**Office of
Environment
& Heritage**

RE: Environmental Assessment Exhibition: Major Project 09_0019 – Riverside Tourist Cabins, New Entrance Road, South West Rocks

ATTACHMENT 2 – OEH ASSESSMENT OF THE PROPOSAL

FIGURE 4
PROVISIONAL HYDRAULIC HAZARD
1% AEP EVENT
PROPOSED DEVELOPMENT

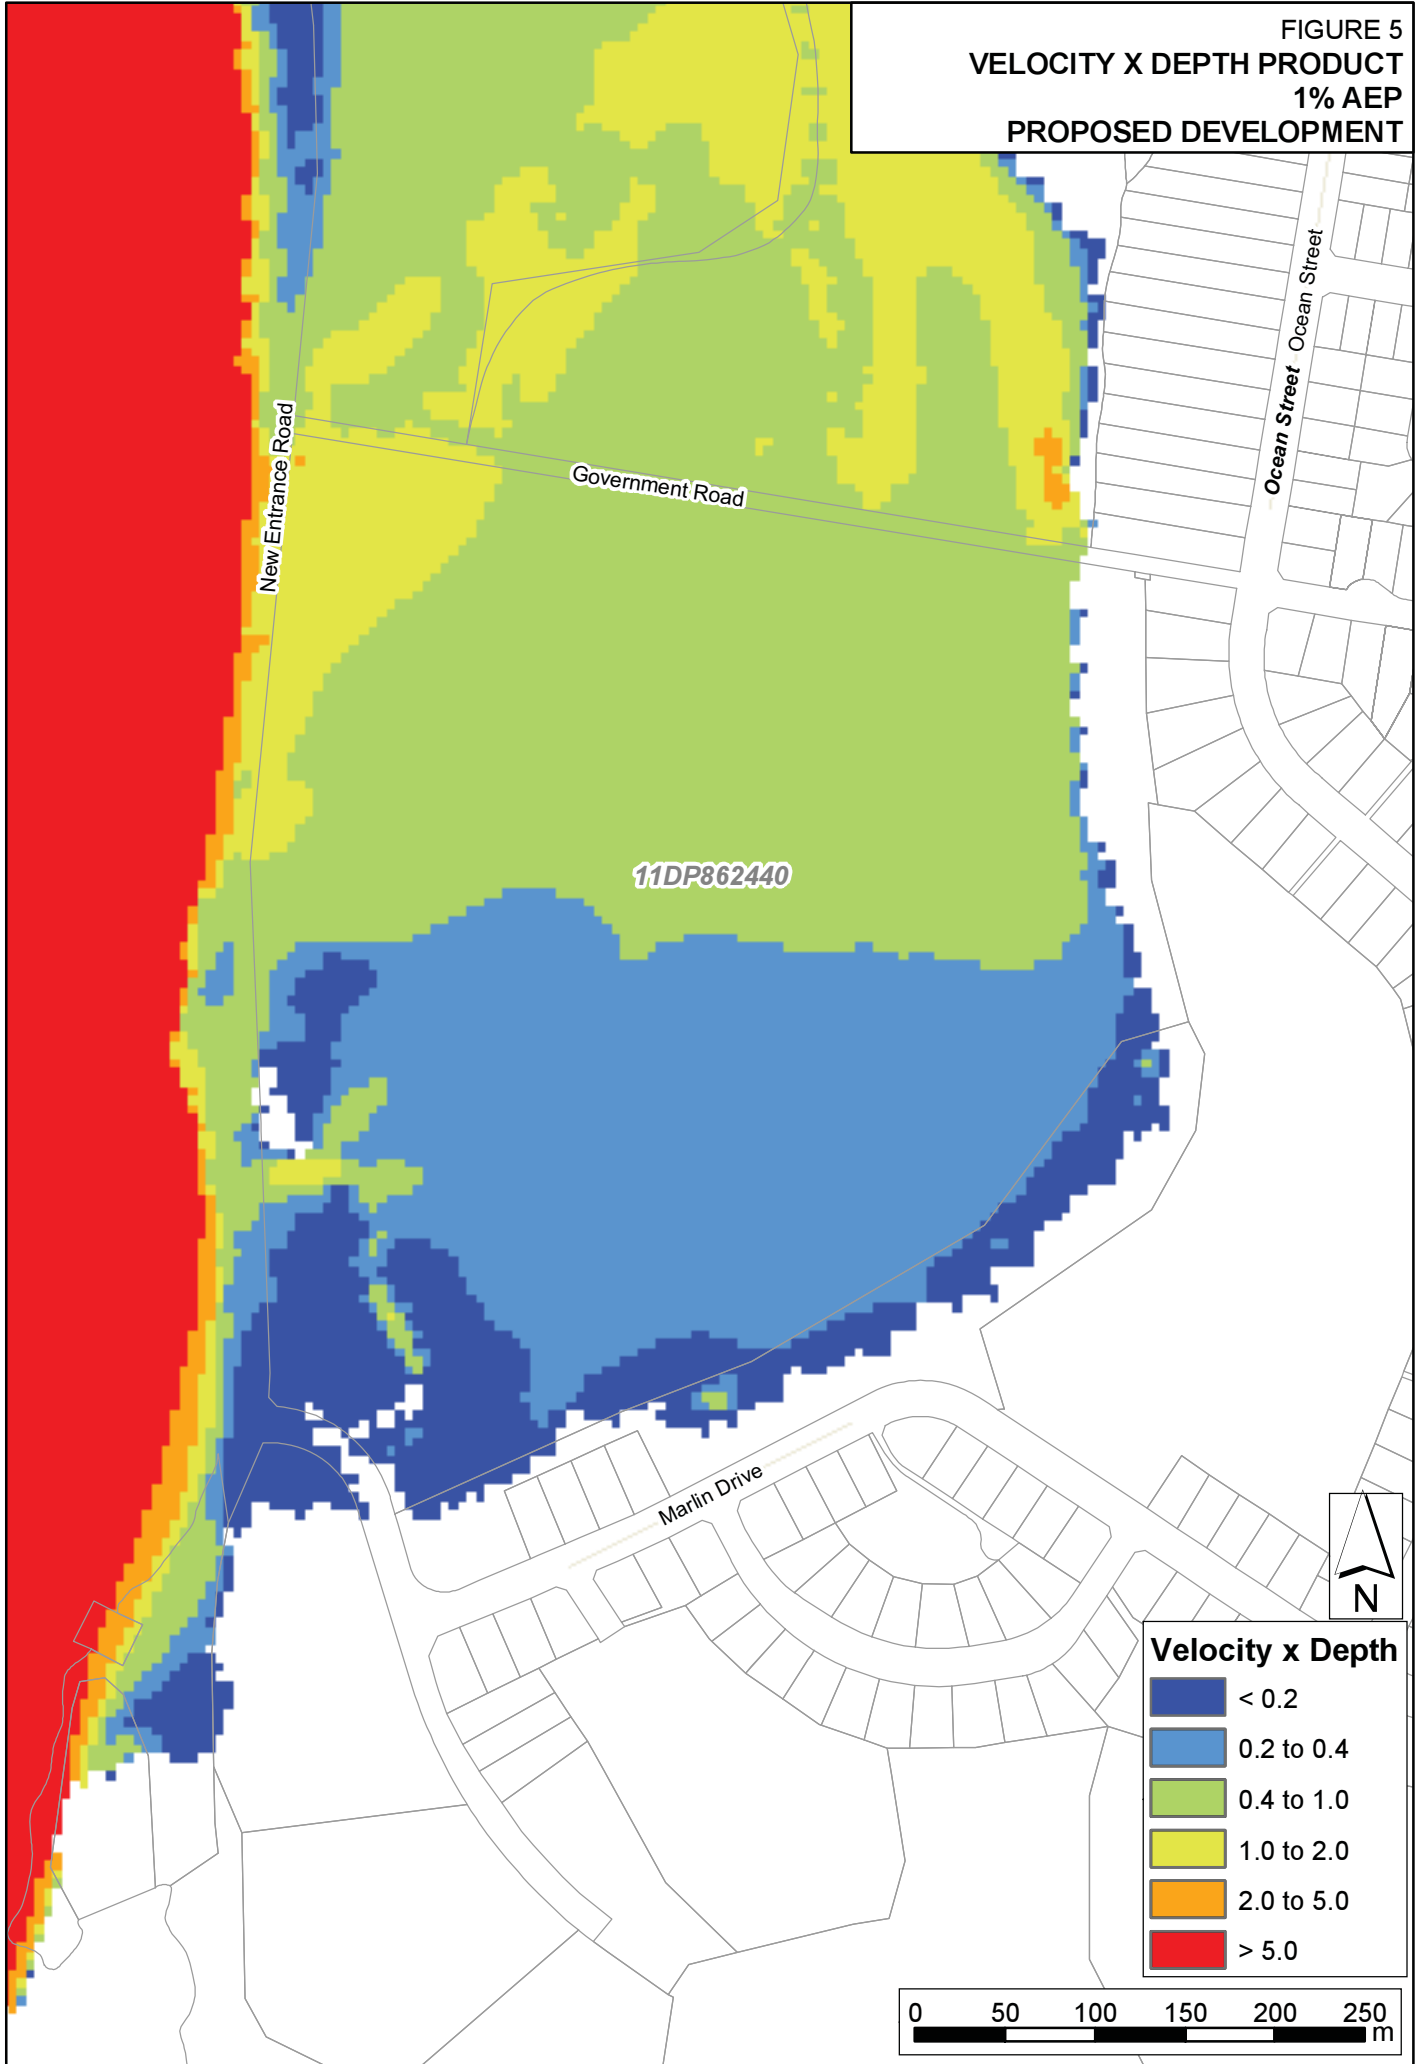
It has been reported in WMA's flood assessment and flood emergency plan (Appendix F) that the site predominantly falls within a High Hazard flood category (Figure 4). However, after filling of the site to 1.9 m AHD a Low Hazard category during a 1 in 100 flood event is generally assigned to the site. However it appears that some part of the site is within a High Hazard category (the product of depth and velocity is greater than 1).

As noted earlier, part of the site would be High Hazard which may affect the proposed evacuation route. It should be noted that if the site is evacuated as planned, then evacuation would be complete prior these hazard conditions being realised.
